**Response to Planning application from Hertfordshire County Council (T and CP GDP Order 2015)**

District ref: 6/2022/2065/COND  
HCC ref: WH/13705/2022  
HCC received: 7 September 2022  
Area manager: Matthew Armstrong  
Case officer: Samuel Tearle

HERTFORDSHIRE CONSTABULARY STANBOROUGH ROAD WELWYN GARDEN CITY AL8 6XF

Submission of details pursuant to conditions 1 (Gosling Sports Park car park), 9 (phase 1 car parking disabled access), 13 (c only) (tree protection), 17 (phase 2 - car parking disabled access), and 20 (phase 3 non-native species management) on planning application 6/2021/2125/MAJ

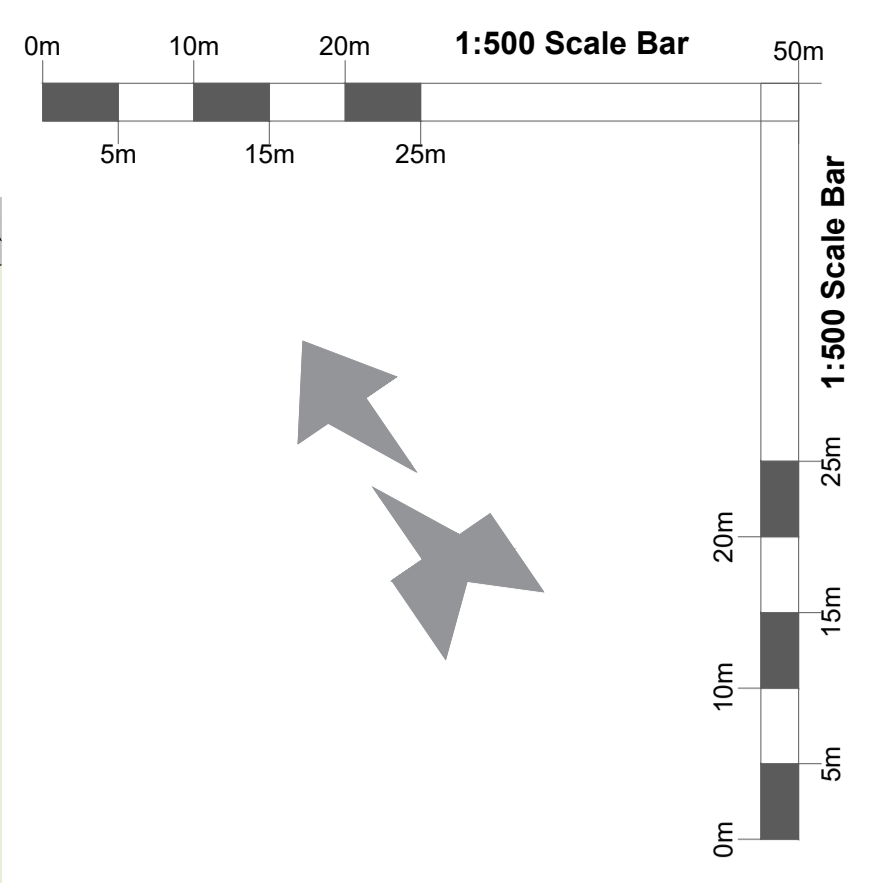
To support the discharge of Condition 1, the applicant has submitted a Letter by Vincent+Gorbing dated 2nd September 2022 and Drawing No. HCHQ-VGA-XX-XX-DR-AR-00140 Rev PL01.

When reviewing the supporting information against the Condition 1 criteria, the Highway Authority note that the extent of blocking off of the car park has been suitable shown, however, the usage of the car park has only been described in the supporting letter as 'low / declining popularity'.

The Local Planning Authority (Welwyn Hatfield) should determine whether this description is acceptable / accurate or whether historical survey data should be obtained.

### Proposed Site Plan Decant accessible parking route to entrance Condition 9

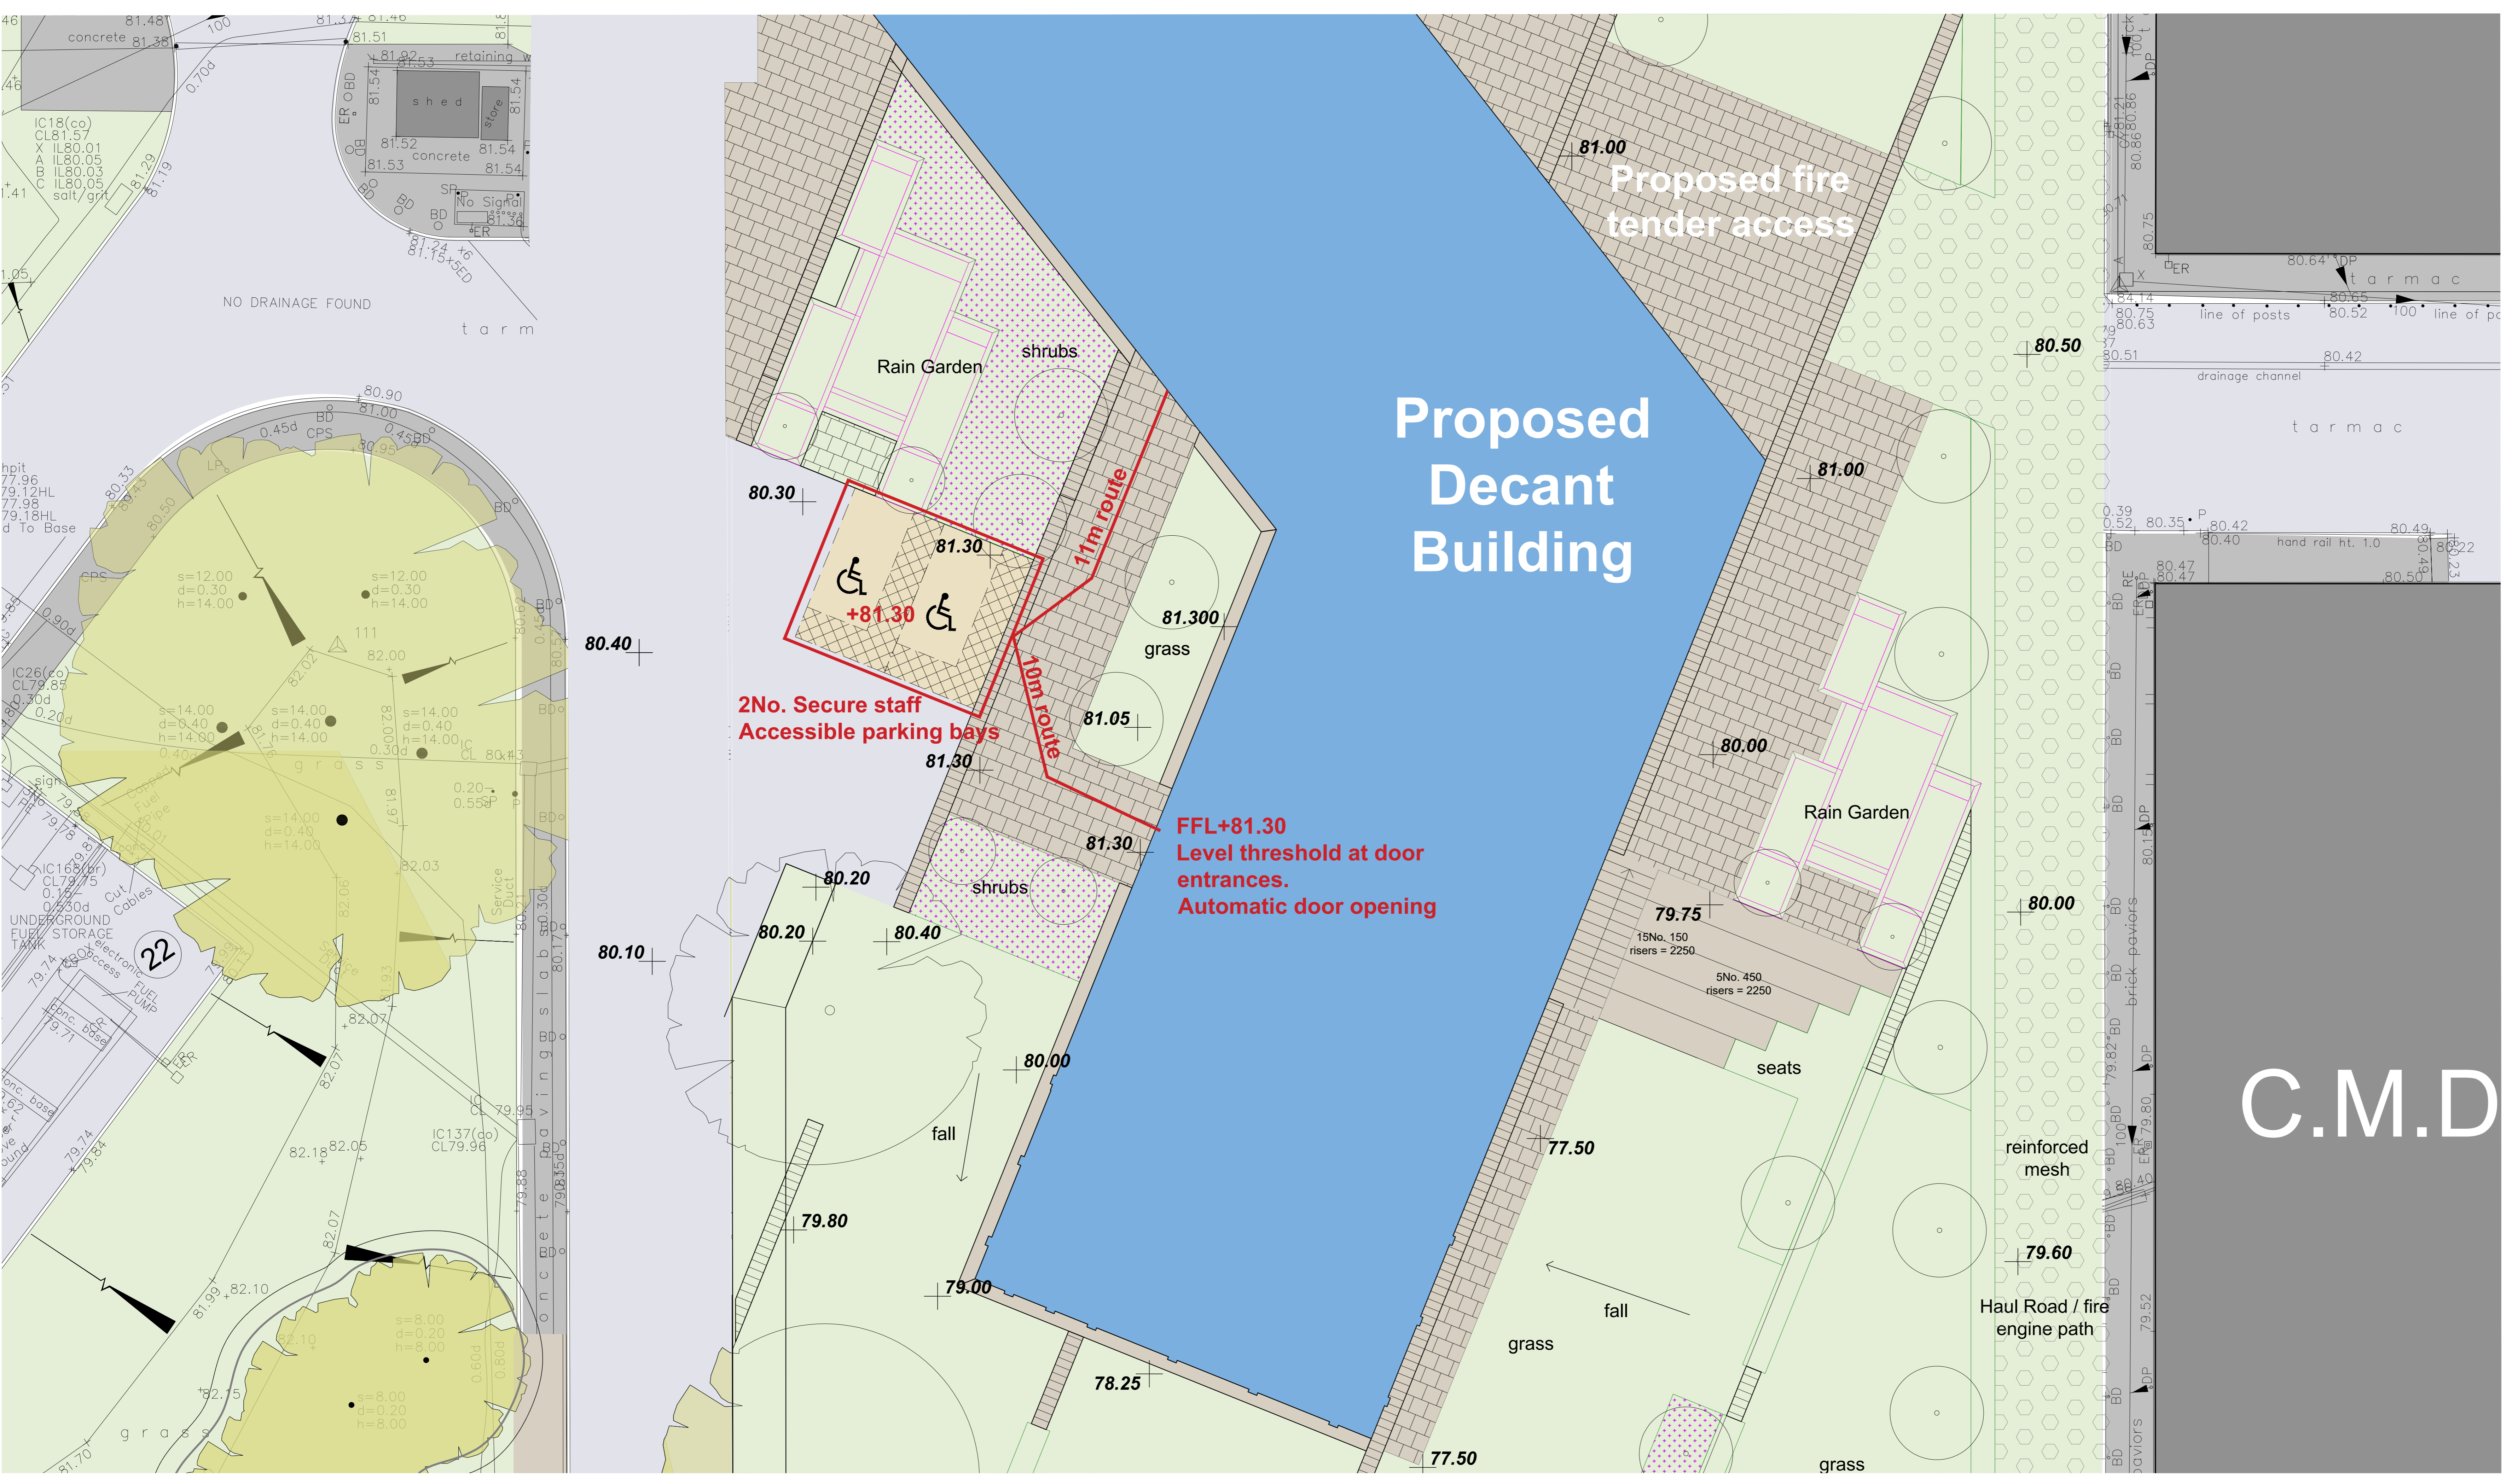
To support the discharge of Condition 9, the applicant has submitted Drawing Nos. HCHQ-VGA-XX-XX-DR-AR-00142 PL01 & AR-00143 PL01 which shows the decant accessible parking route to entrance and the Dog Unit respectively. The Highway Authority have reviewed the drawings and does not wish to raise an objection.

Proposed Site Plan HQ Accessible parking route to entrance Condition 17

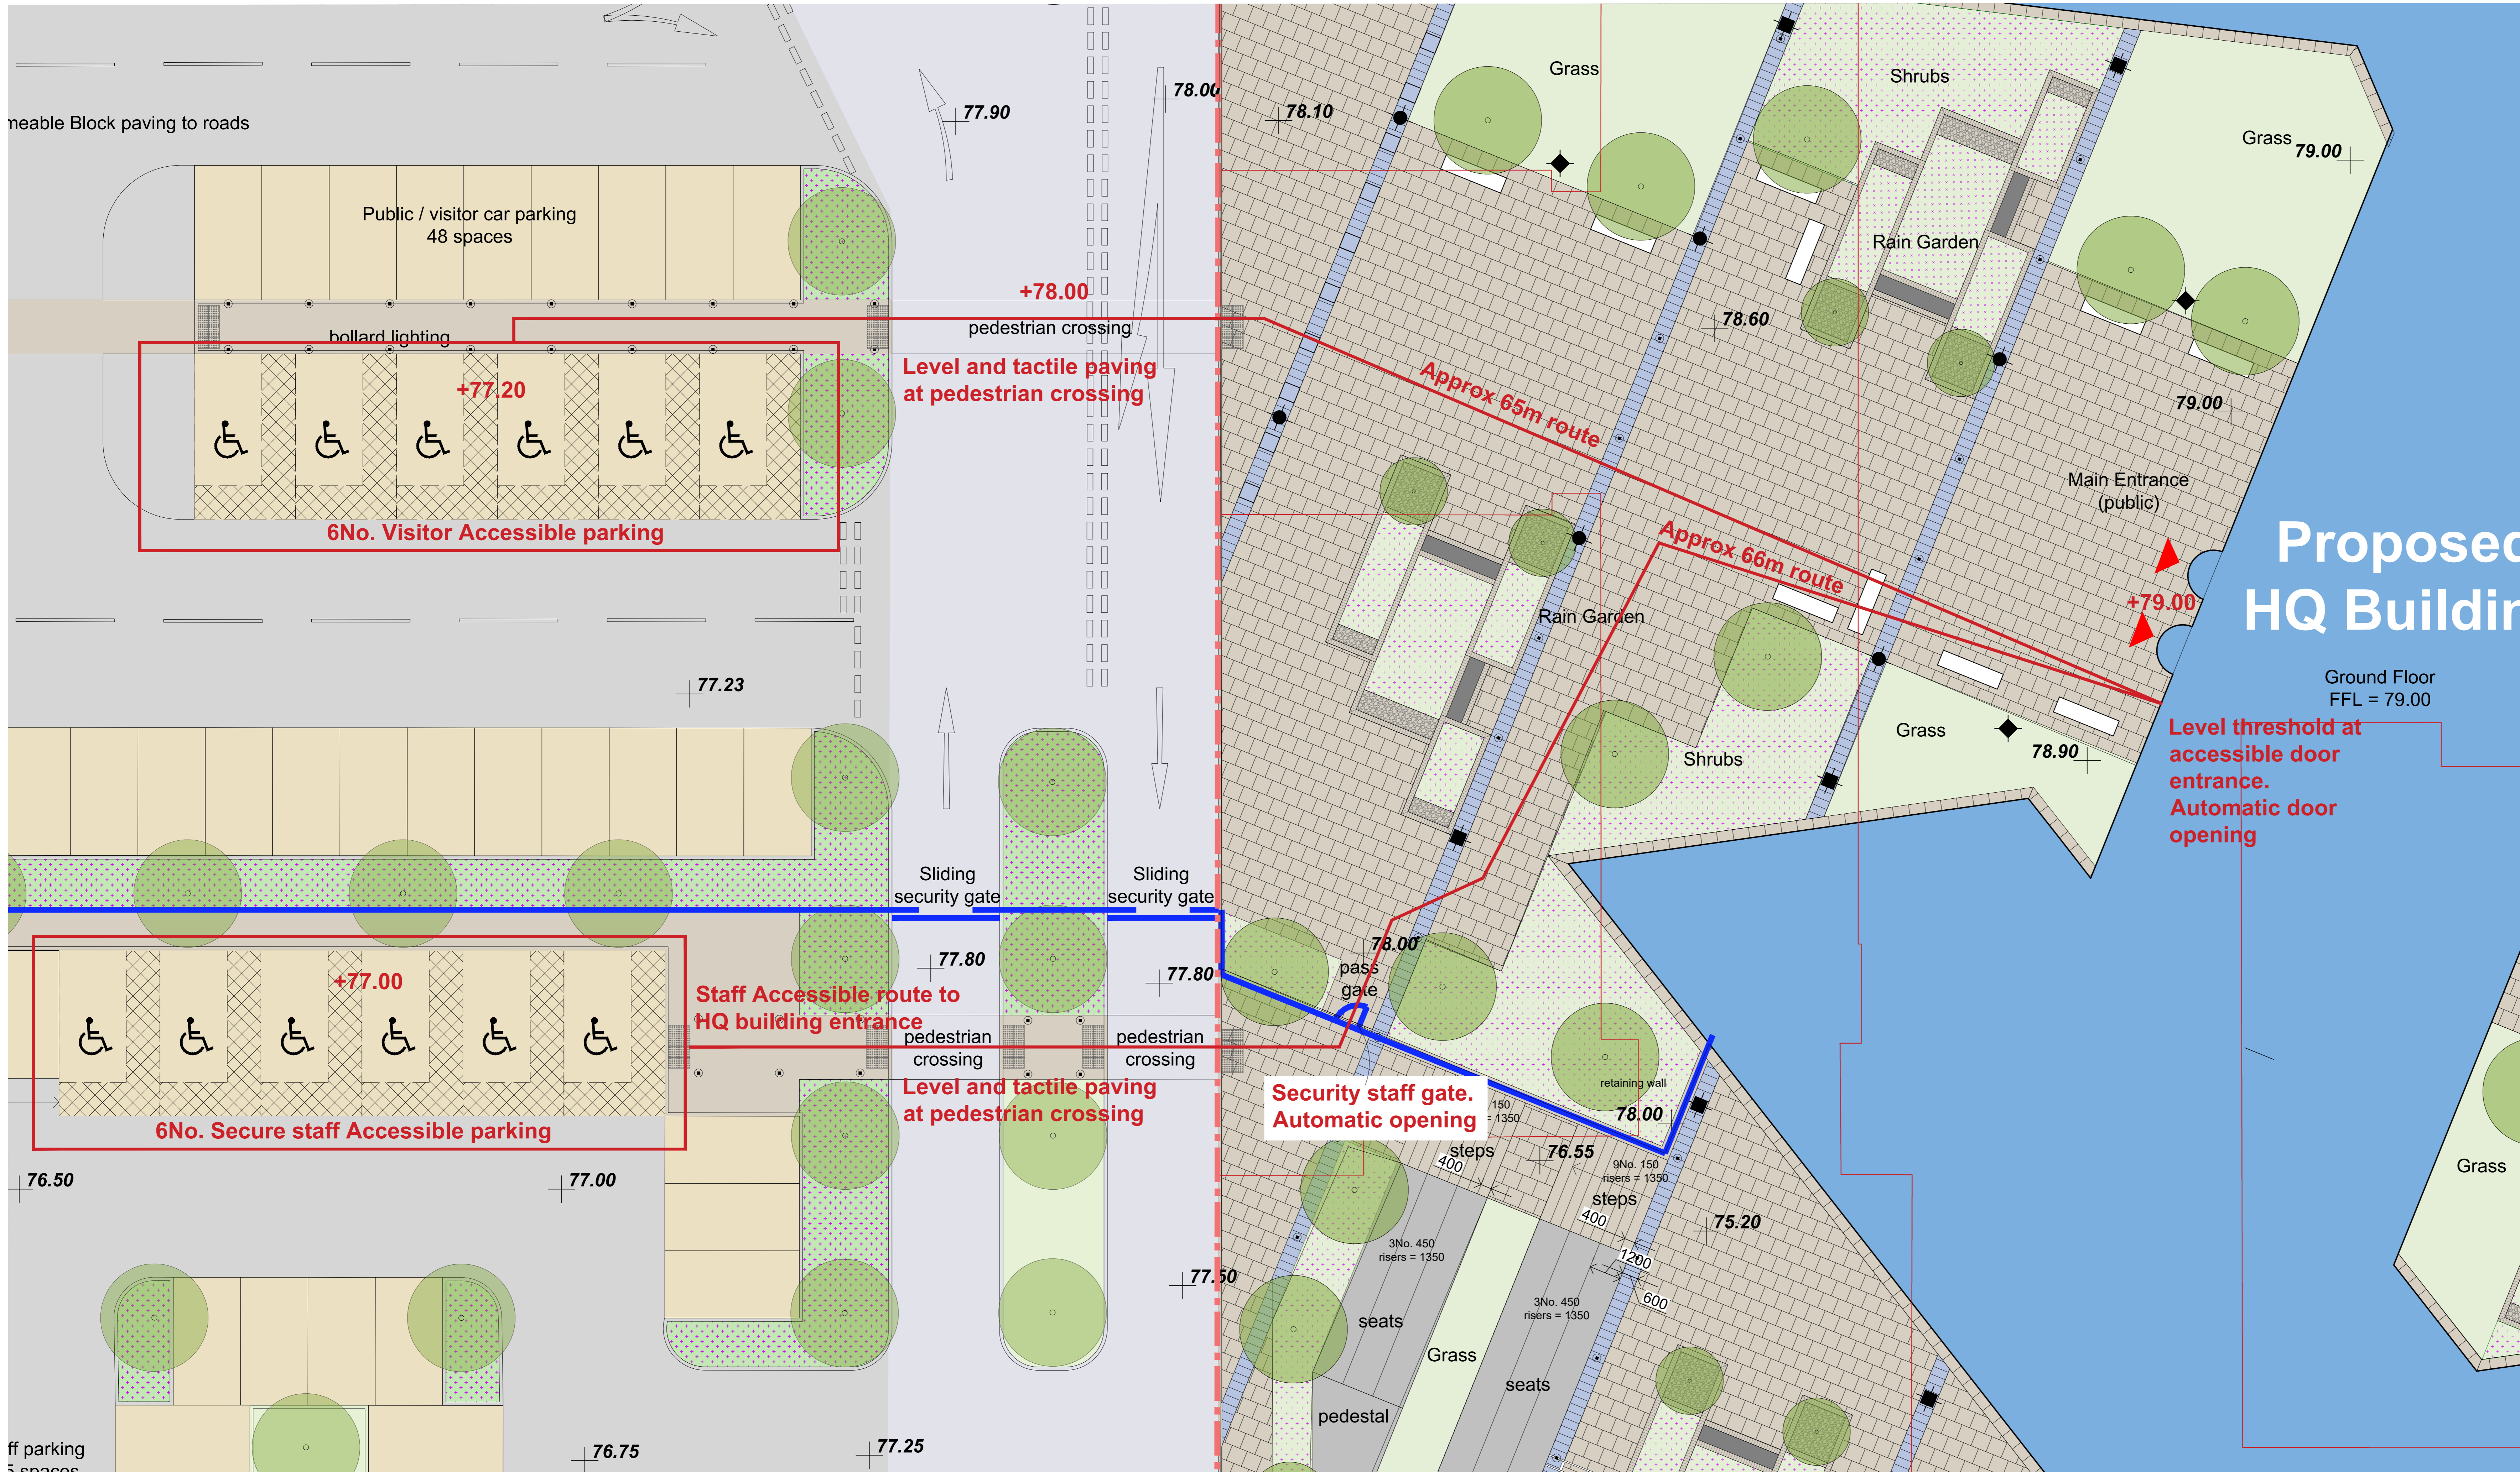
To support the discharge of Condition 17, the applicant has submitted Drawing No. DR-AR-00144 Rev PL01 which shows the accessible route to the building entrance. The Highway Authority have reviewed the drawings and does not wish to raise an objection.
